EPC STORMWATER REVIEW COMMENTS
 IN ORANGE BOXES WITH BLACK TEXT

EL PASO COUNTY STORMWATER MANAGEMENT PLAN CHECKLIST

EPC Project Number: VR239

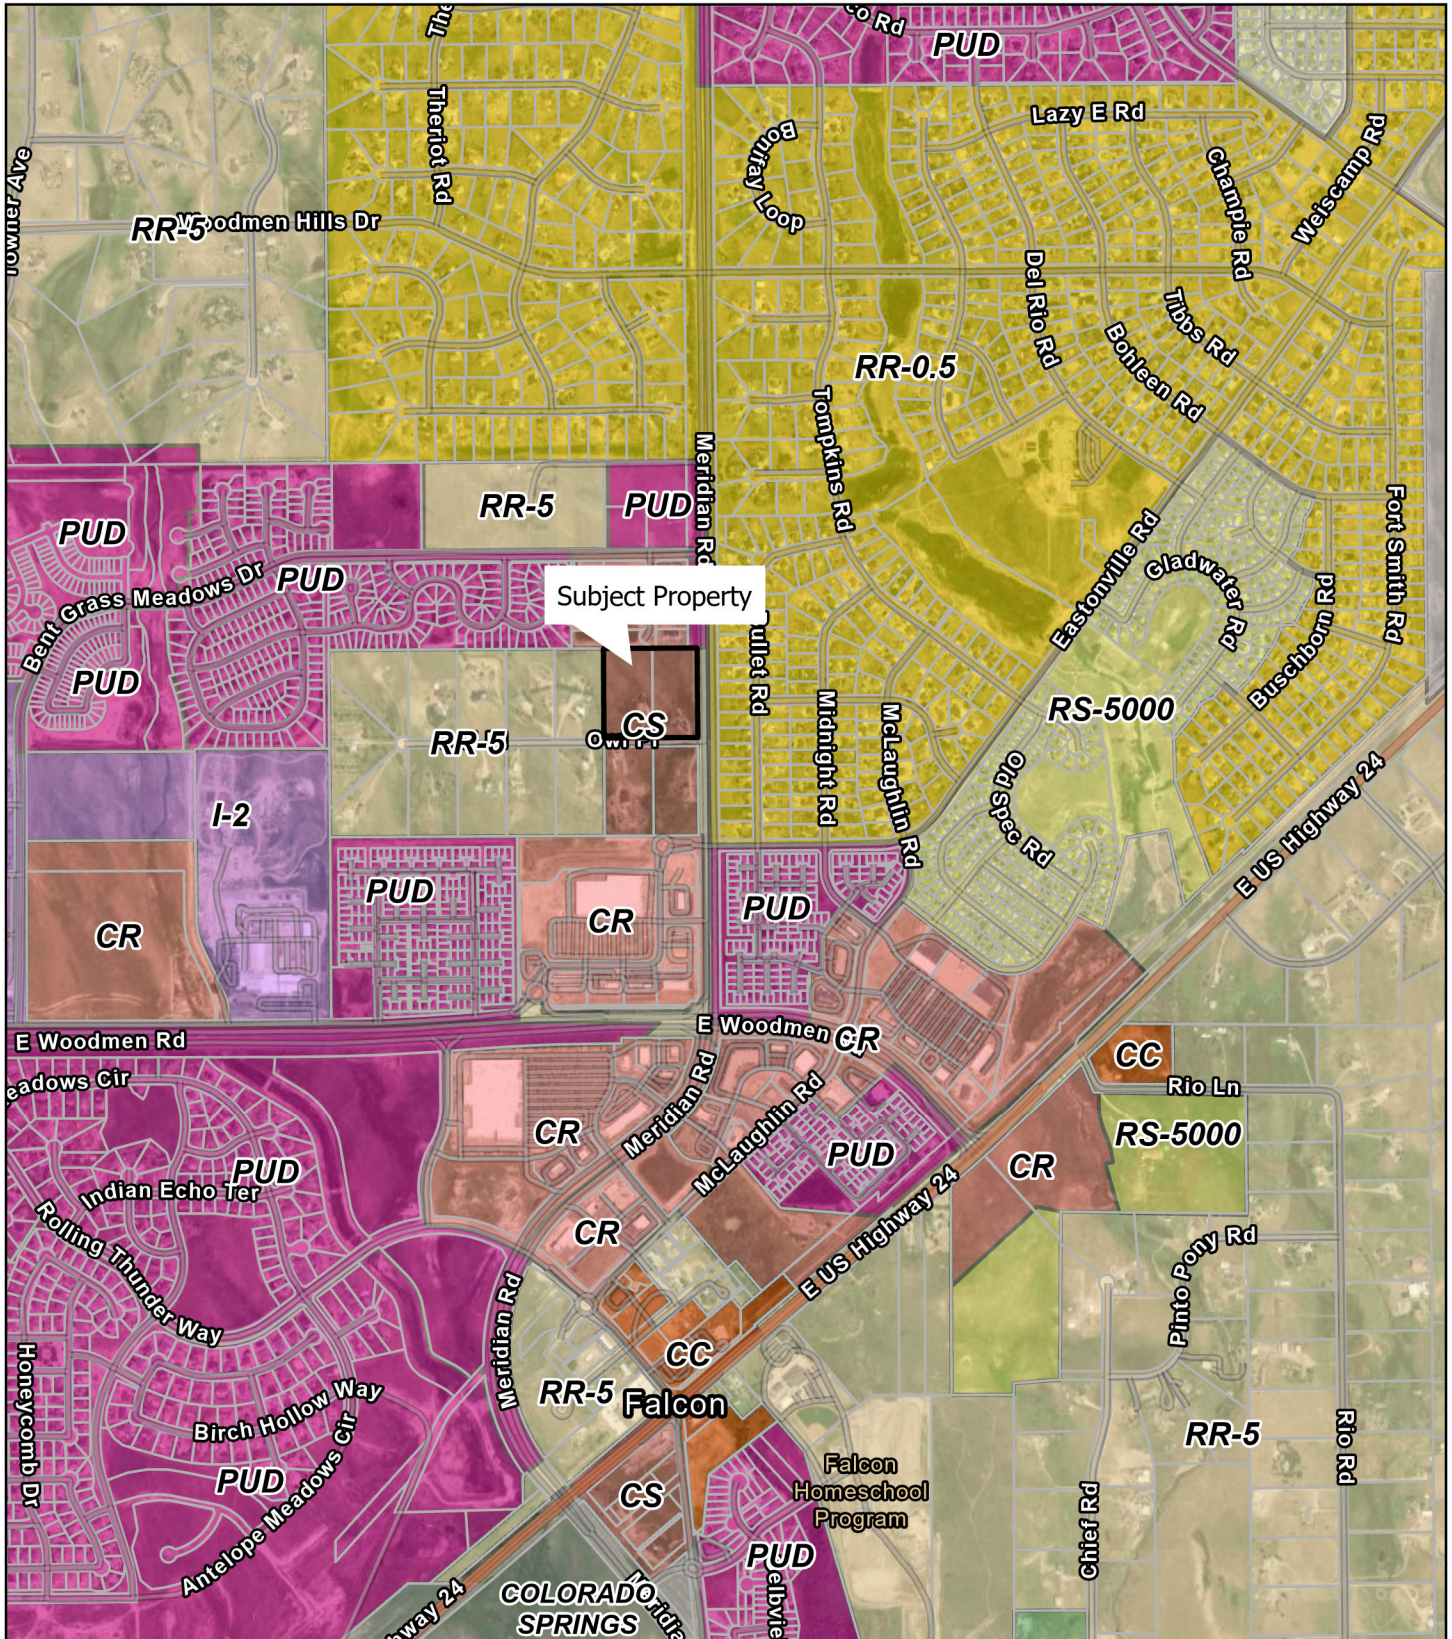
Applicant	EPC
17	SWMP Map to include: GEC Plan reviewed:		
17a	construction site boundaries		Y
17b	flow arrows to depict stormwater flow directions		Y
17c	all areas of disturbance		Y
17d	areas of cut and fill		Y
17e	areas used for storage of building materials, soils (stockpiles) or wastes		Y
17f	location of any dedicated asphalt / concrete batch plants		N
17g	location of all structural control measures		Y
17h	location of all non-structural control measures		Y
17i	springs, streams, wetlands and other surface waters, including areas that require maintenance of pre-existing vegetation within 50 feet of a receiving water		Y
18	Narrative description of all structural control measures to be used. Modifications to EPC standard control measures must meet or exceed County-approved details		Y
19	Description of all non-structural control measures to be used including seeding, mulching, protection of existing vegetation, site watering, sod placement, etc.		Y
